Application Ref:	3/2021/0410	 Ribble Valley Borough Council www.ribblevalley.gov.uk
Date Inspected:	15/7/2021	
Officer:	AD	
DELEGATED ITEM FILE REPORT:		Decision Refusal

Development Description:	Proposed conversion of part of barn to one bedroomed dwelling and creation of a garden and parking area (part retrospective)
Site Address/Location:	Parker Place Farm Pendleton Road Wiswell BB7 9BZ

Drawing Title
Existing Elevations

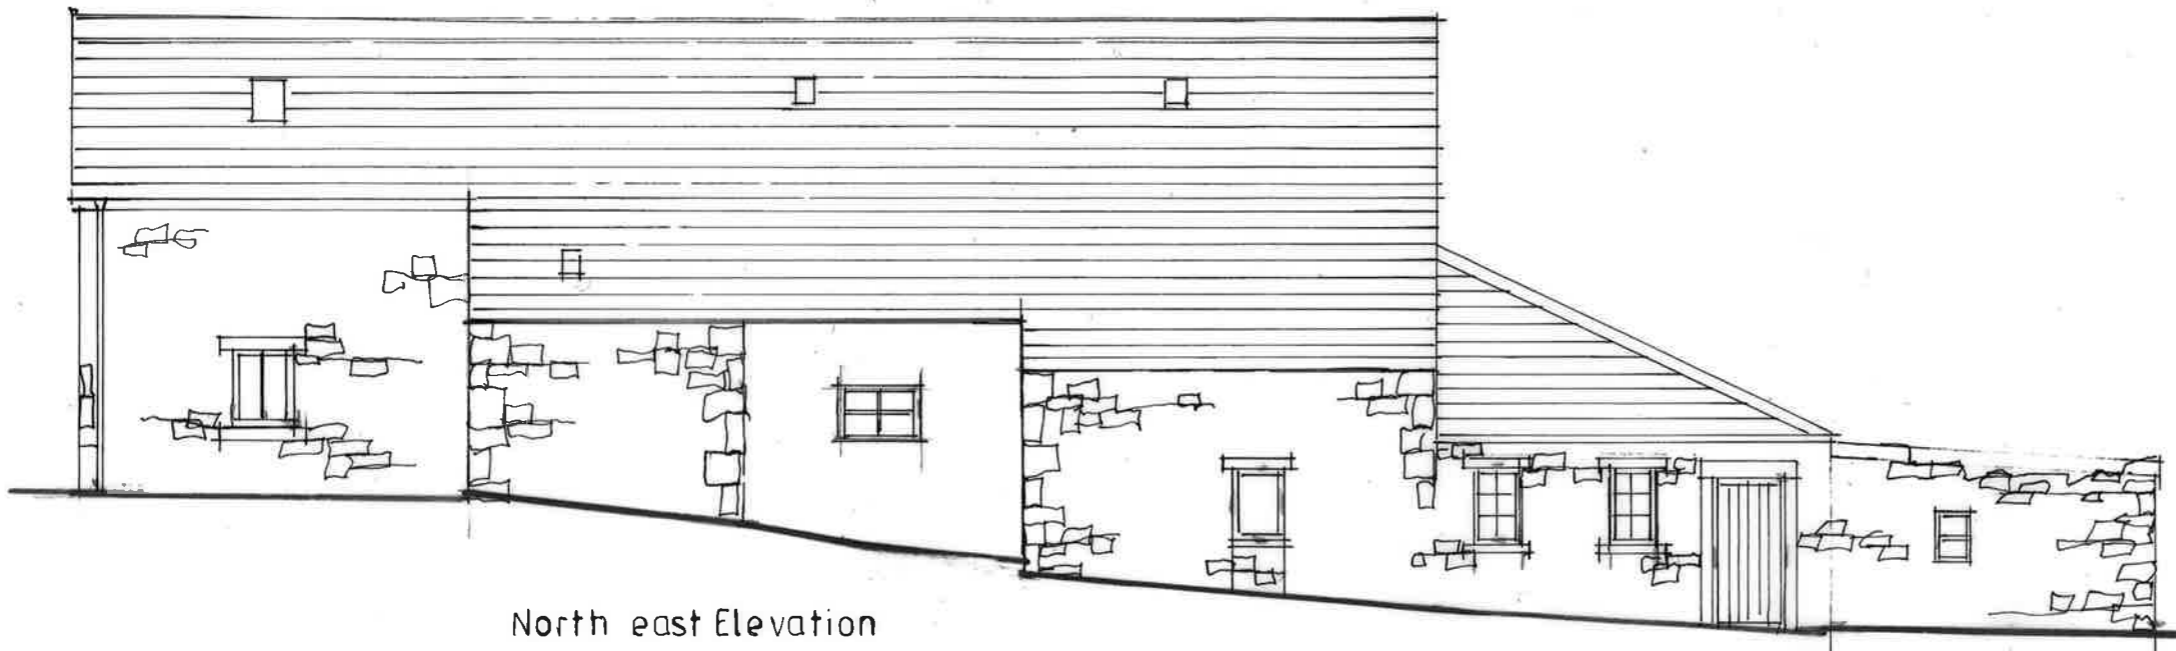
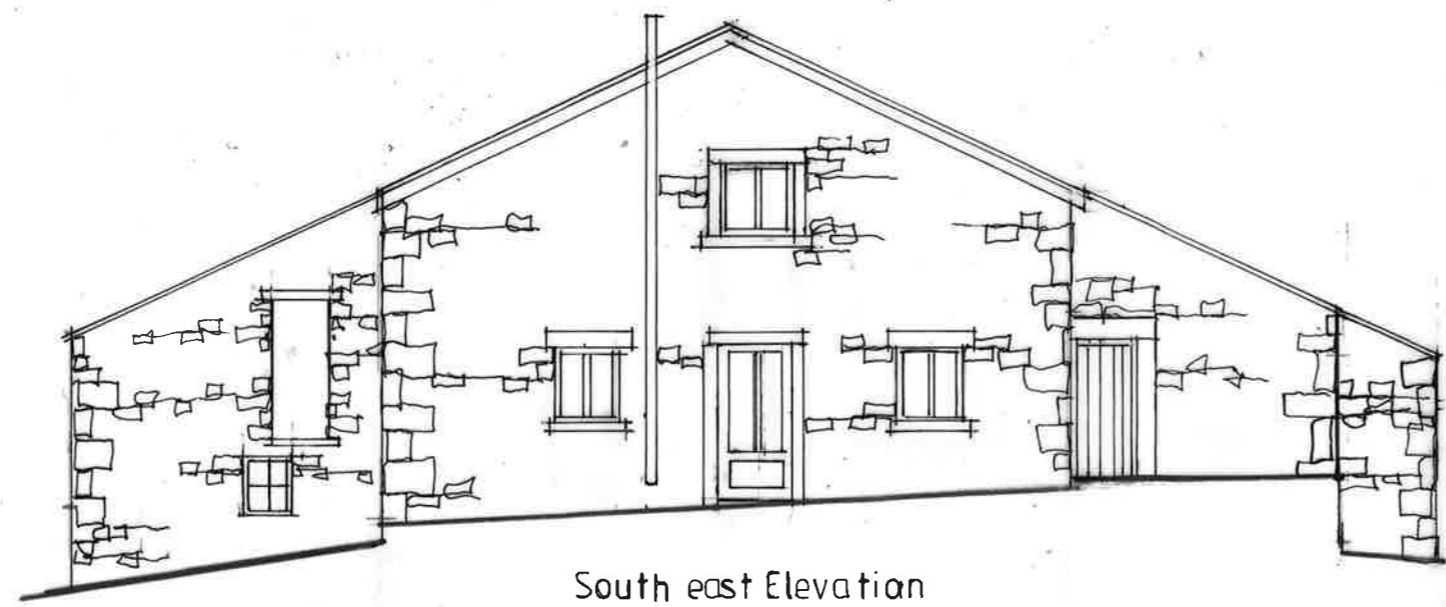
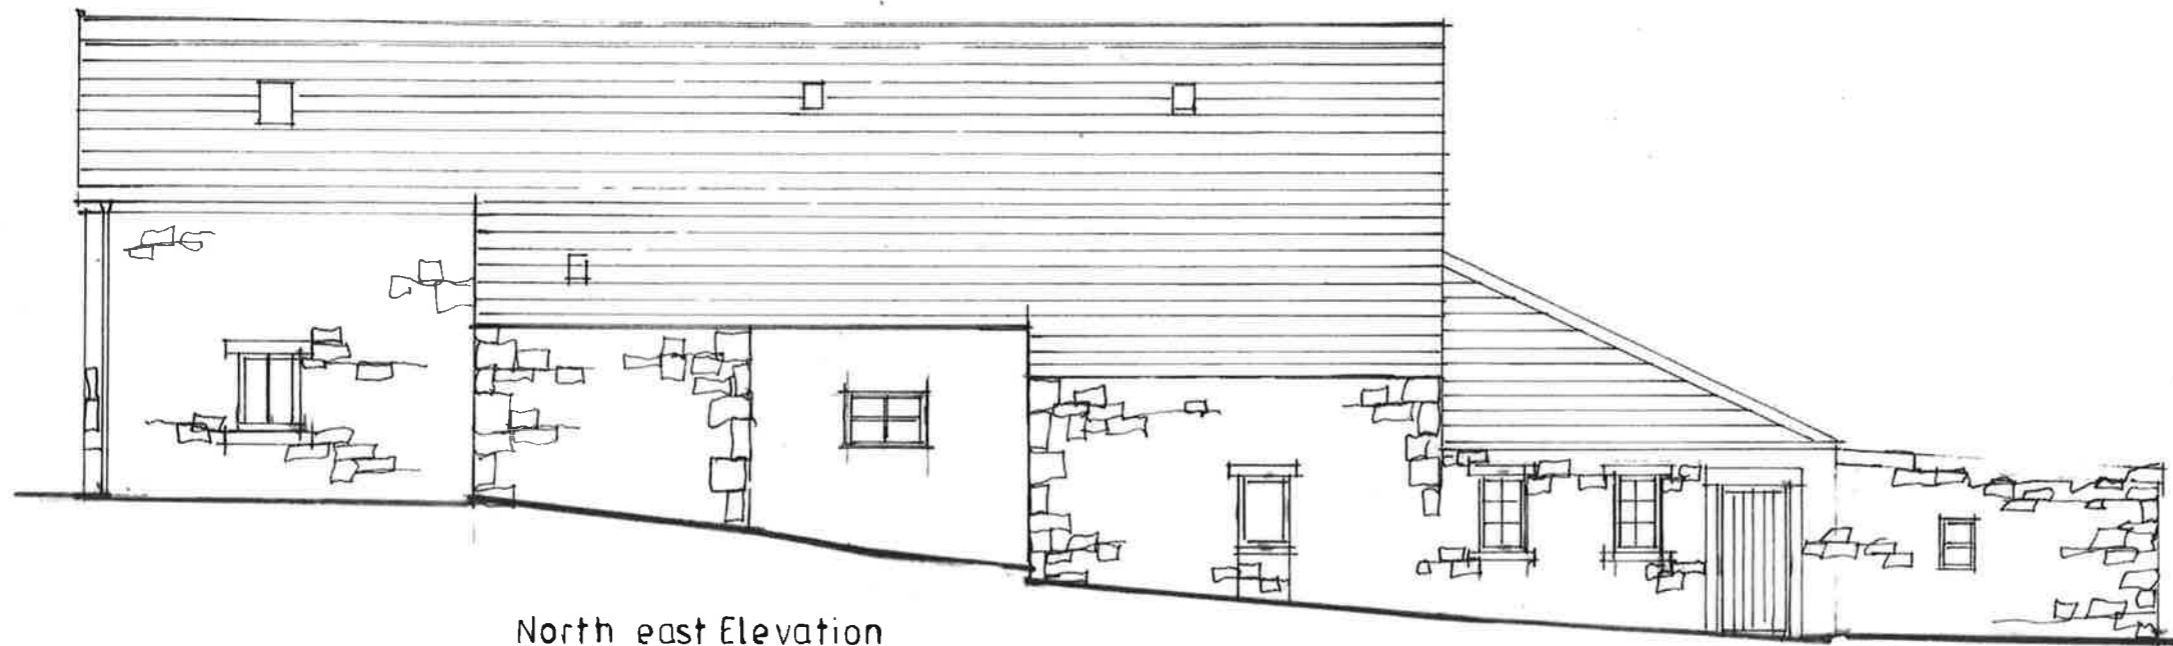
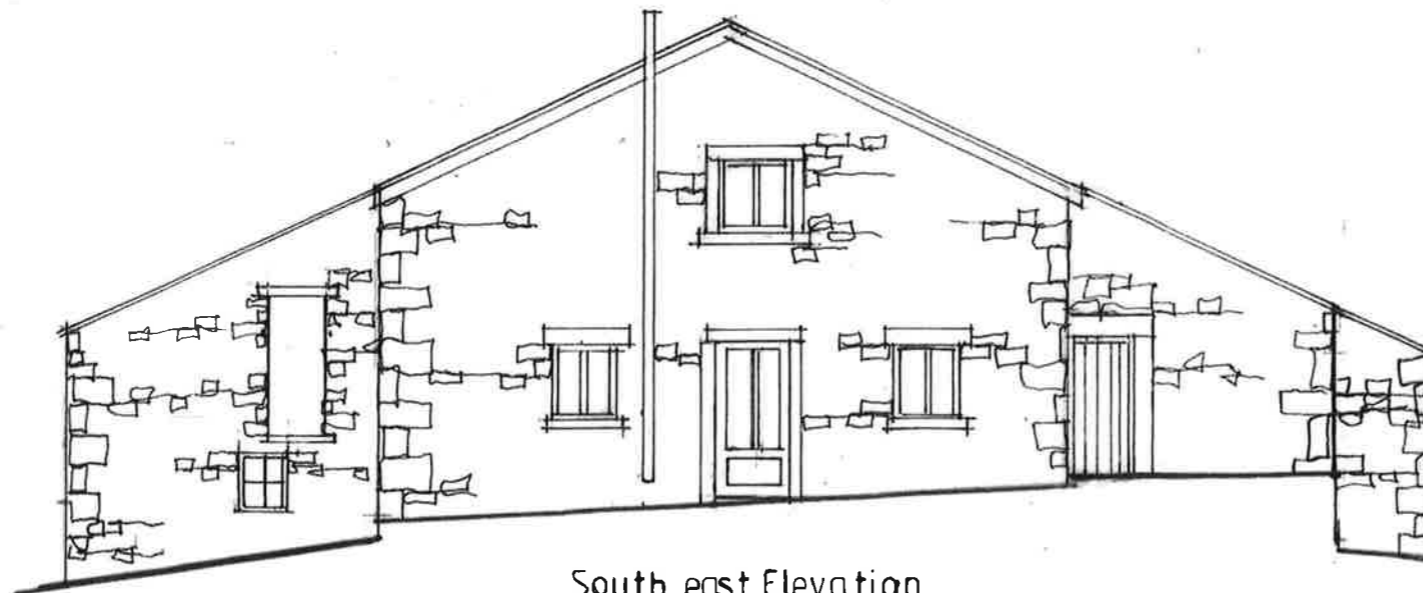
Unfortunately, the submitted plans do not clarify the impact of the unauthorised works – existing and proposed drawings are very similar (see proposed drawing for 3/1974/0231 showing no openings to the east gable). Only recent photographs have been submitted. However, the submitted Heritage Statement (7.1.1) identifies that the following works have been undertaken (case officer notes following site inspection in brackets):

Re-roofing using existing stone slates and ridge tiles. The existing timber roof structure has been retained. Installation of oak fascia and barge boards. (*no fascia and barge boards on rest of barn – is this a new feature?*)

Installation of timber effect double glazed windows (*i.e. plastic imitating stained timber*).

Installation of 2no flush fitting conservation roof lights to the north and south roof slopes to replace preexisting glass slates. (*there are x2 rooflights to the south elevation facing the farmhouse*)

The implemented works are conspicuous and incongruous and have had a harmful impact upon the harmonic relationship of farmhouse and barn and the setting of the listed building because of the materials (plastic windows imitating stained timber; largely glazed door to gable; lean-to corrugated roof; no evidence submitted to justify replacement of historic stone heads and jambs) used and domestic form (x2 rooflights breaking up stone slate roof facing house; weathervane; soil pipe; rainwater goods including spuriously dated hoppers; verge and bargeboards) of alterations in the conversion.

Drawing Title
Existing Elevations

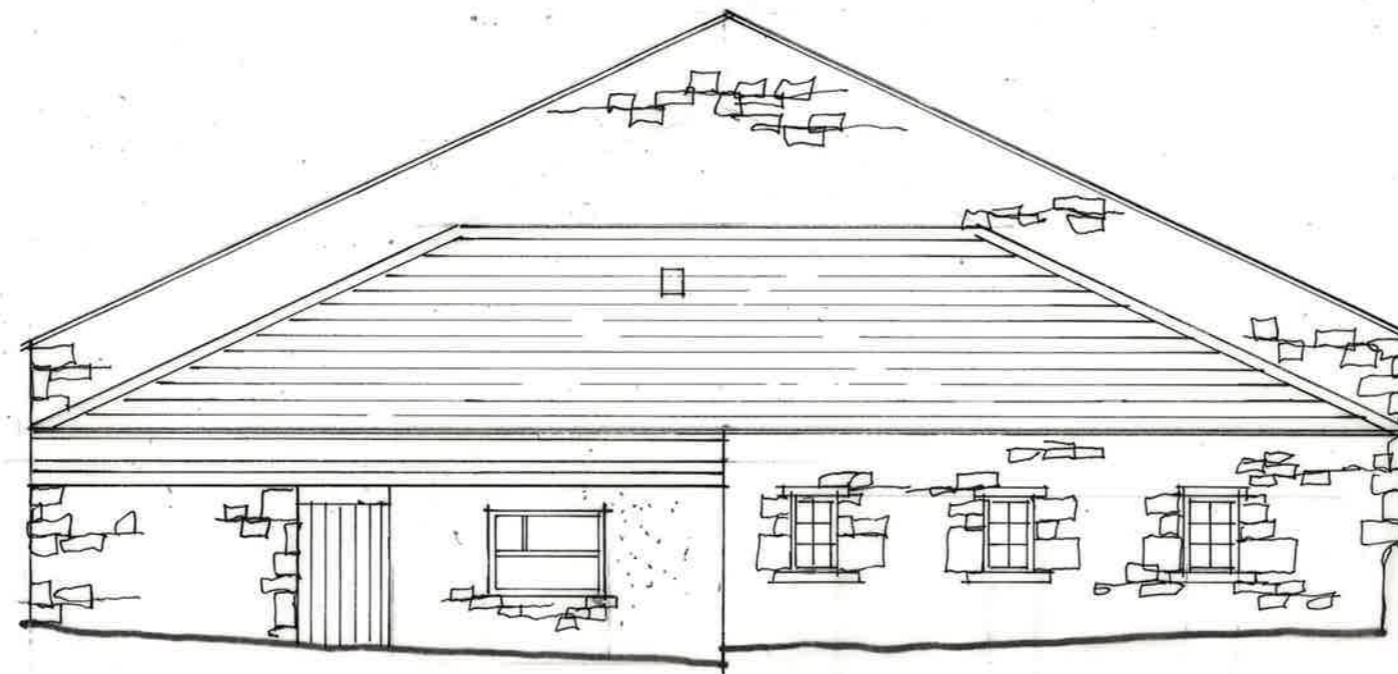
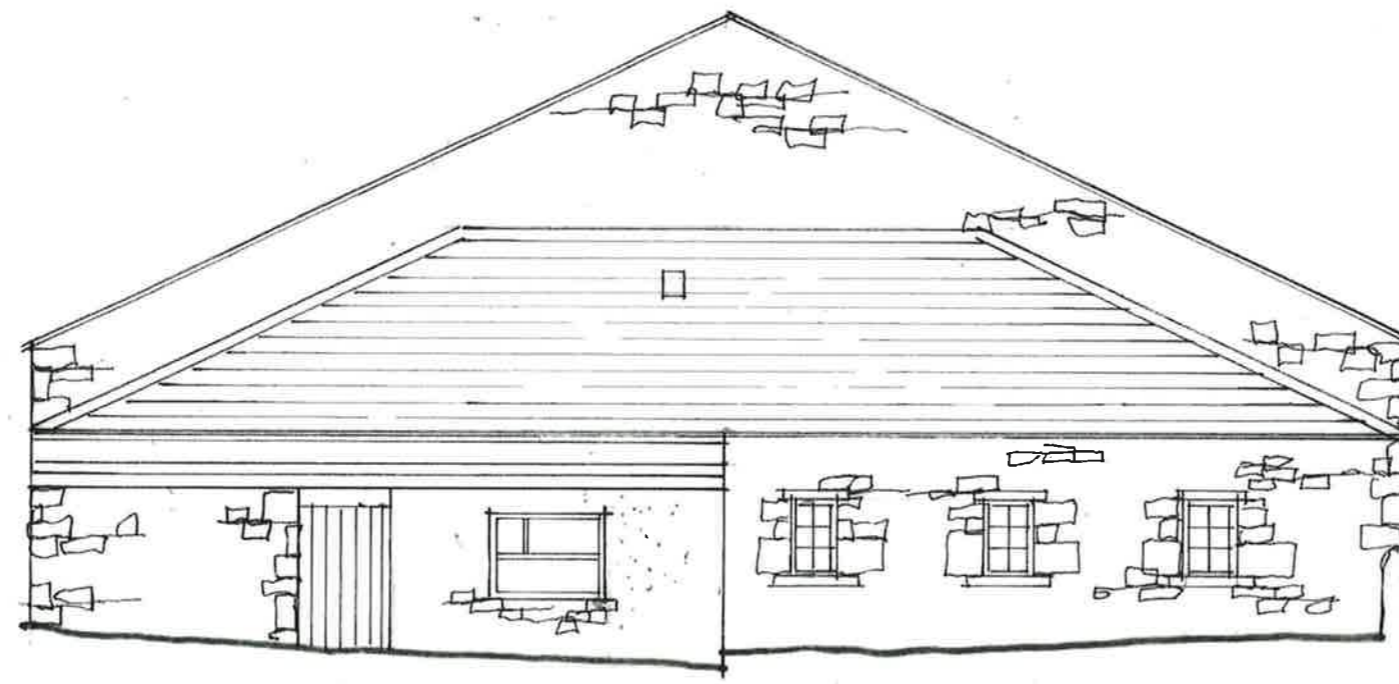
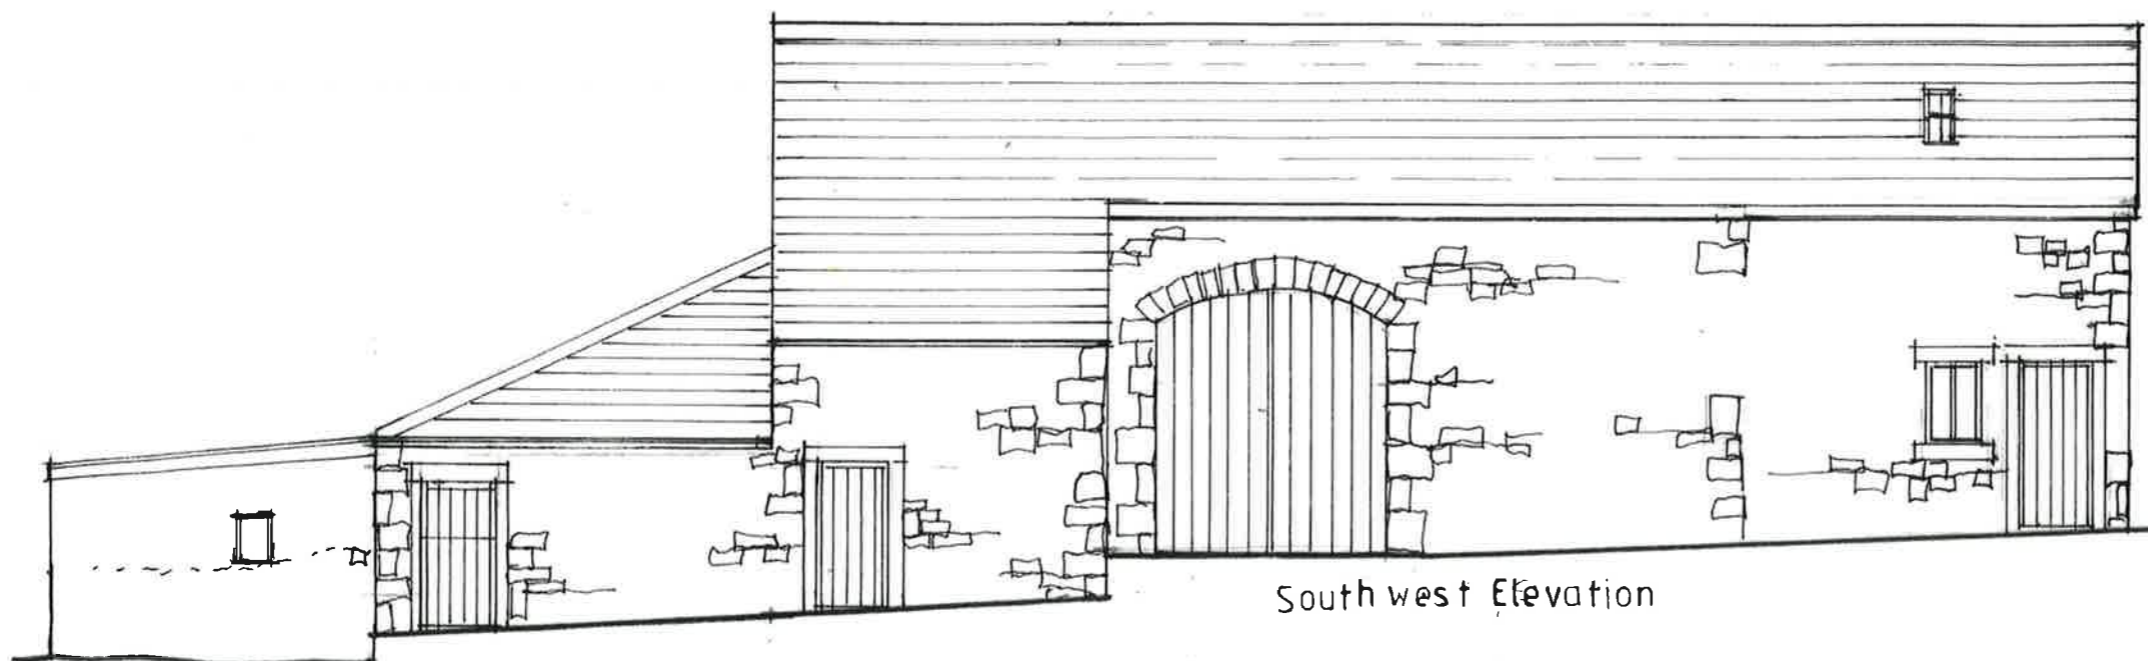
A modern corrugated roofed lean-to (of recent appearance but with late C19 dated hopper) has been attached to the south elevation (facing the farmhouse). However, this is not identified on the submitted plans.
